Airport Industrial Property Unit Trust ('AIPUT') hereby provides a brief Deadline 2 submission relating to the examination of the application made by Gatwick Airport Limited ('GAL') for a development consent order ('the DCO application') for the Gatwick Northern Runway Project ('the Project') under the Planning Act 2008 ('PA 2008').

REVIEW OF GATWICK AIRPORT LIMITED'S (GAL) DEADLINE 1 SUBMISSIONS

Surface Access Highways Plans – Structure Section Drawings – For Approval

Project Code-Location-Discipline-Volume-Type-Unique Number
41700- XX -B- LLO- GA - 200174 P01

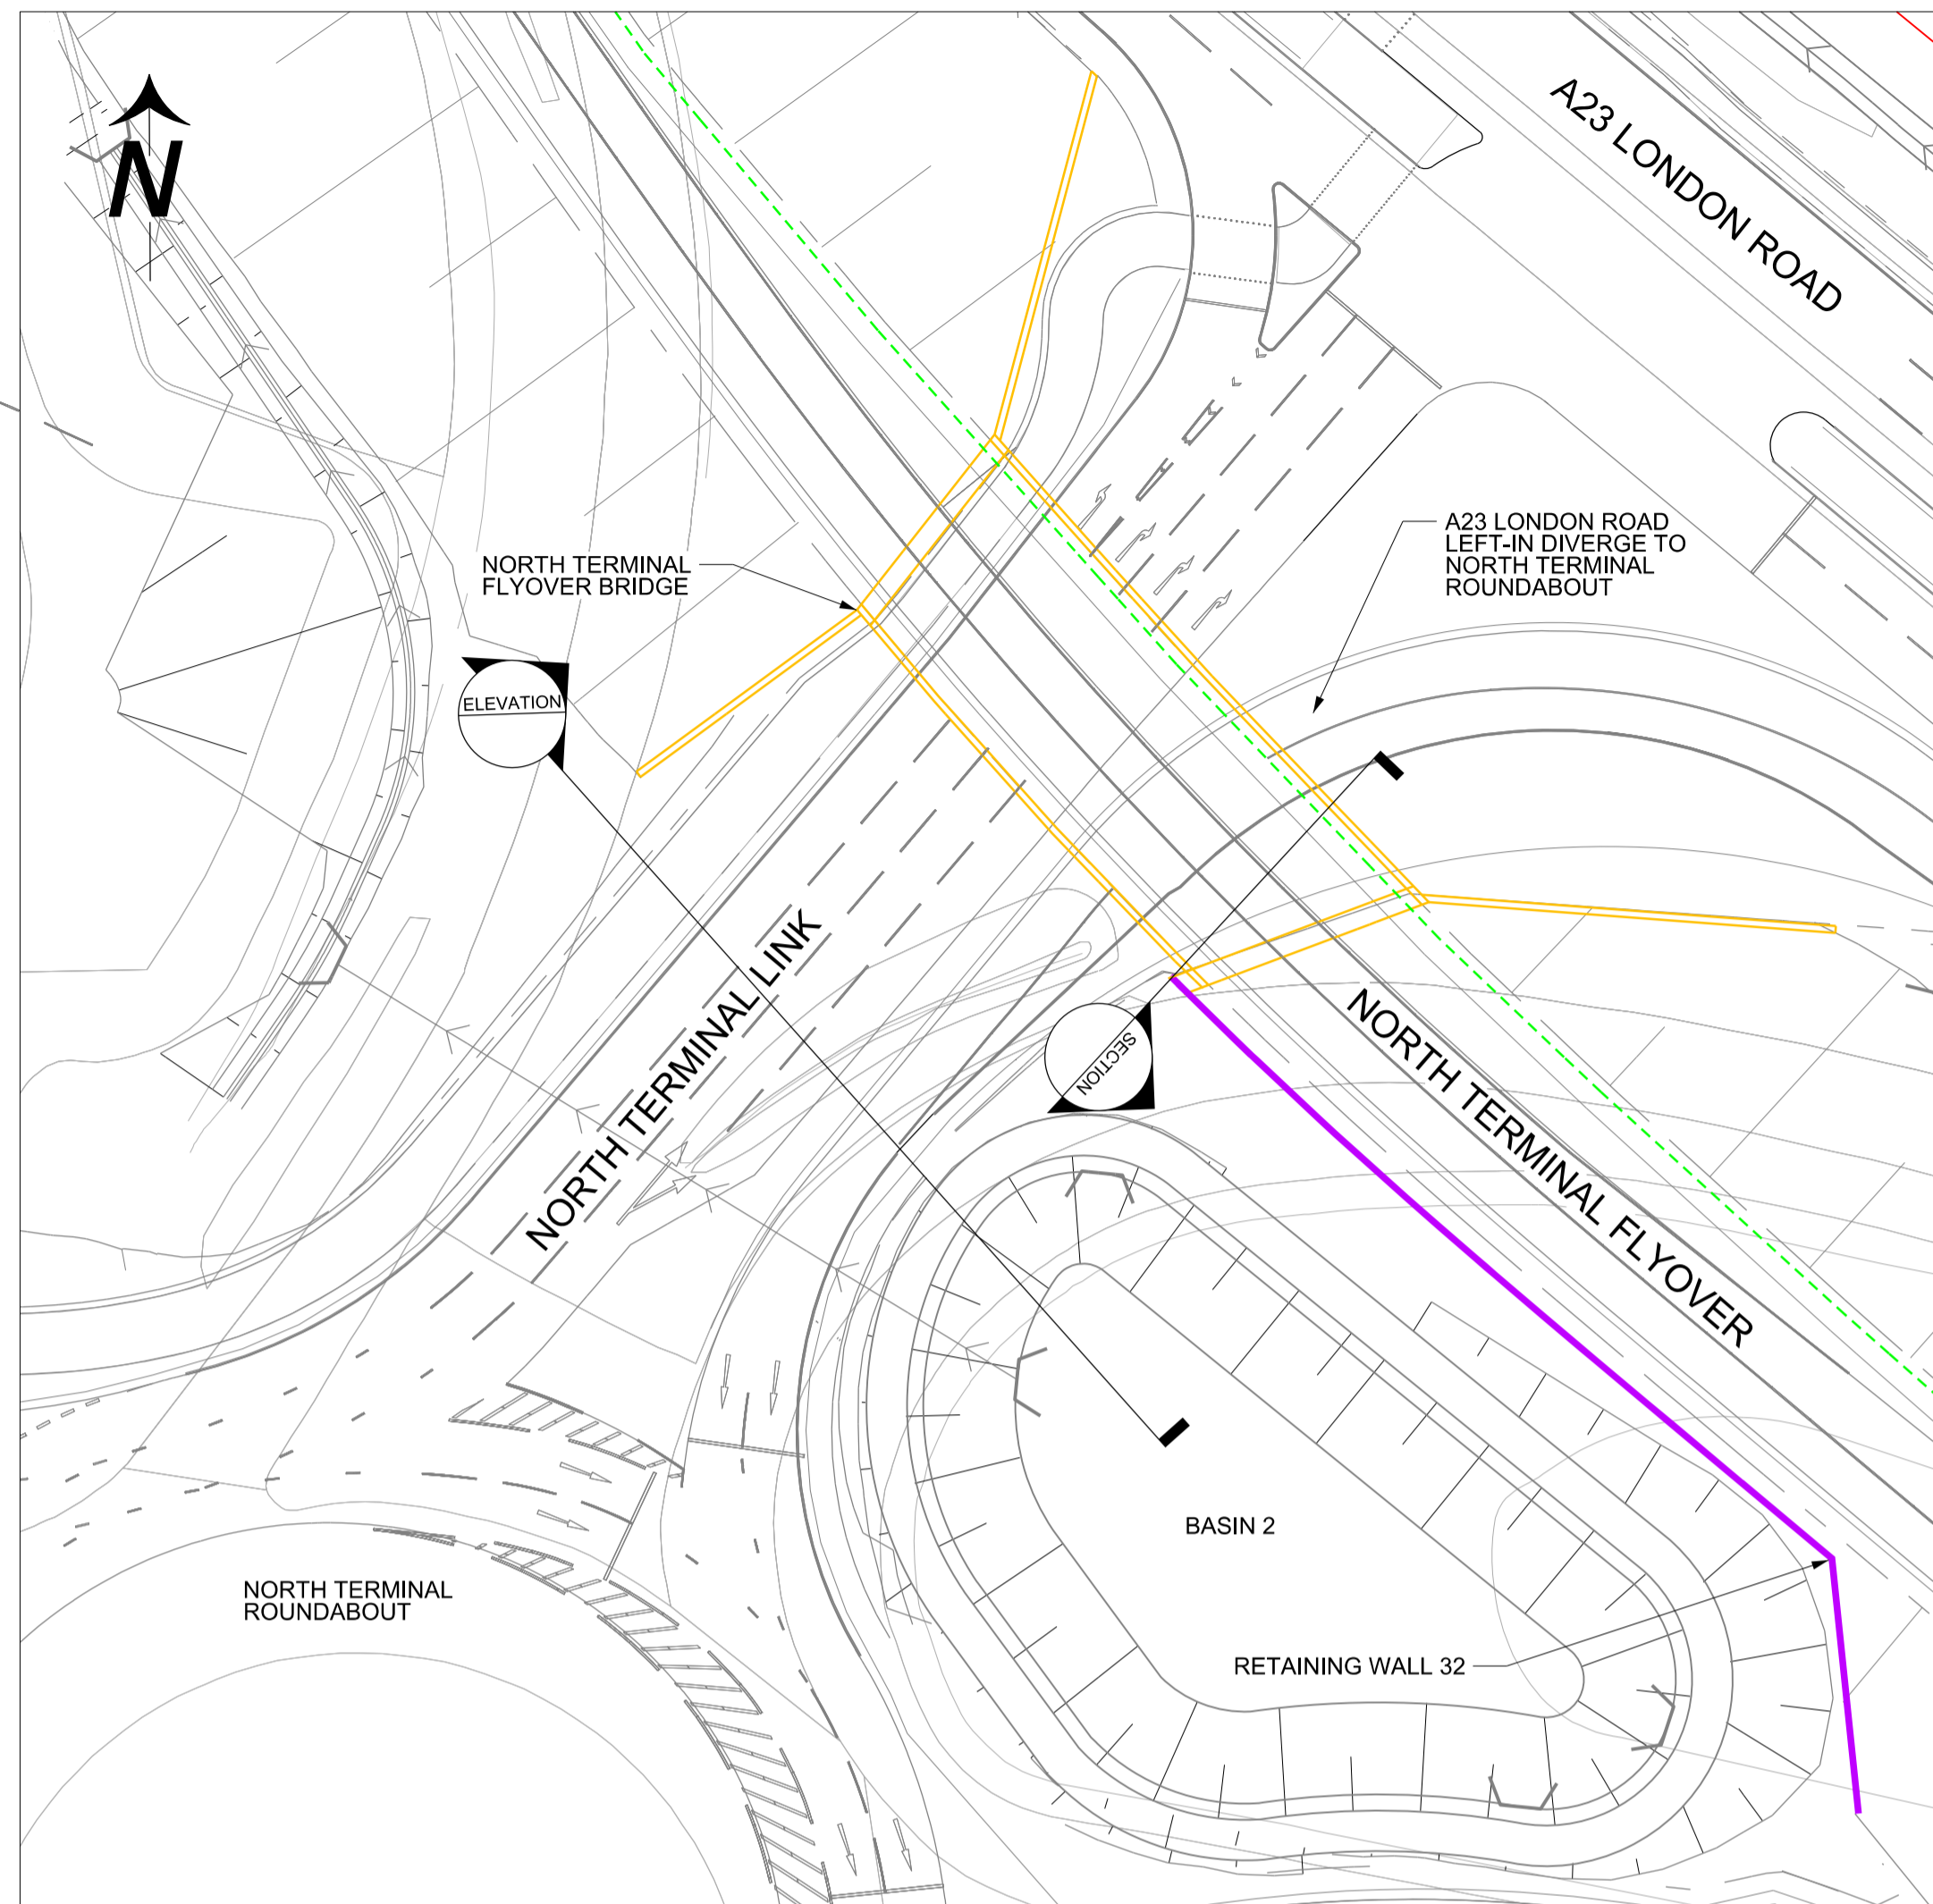
The structure section drawings are welcomed by AIPUT and provide some detail to the surface access highway plans being proposed. Motion would like to query on behalf of AIPUT, how the lane widths have been determined. For instance, the two-way single carriage ways are labelled as 7.25m despite a width of 7.3m being the established DMRB requirement, suggesting unfamiliarity with DMRB. AIPUT would also request that dimensioned plans are provided for junctions across the highway network.
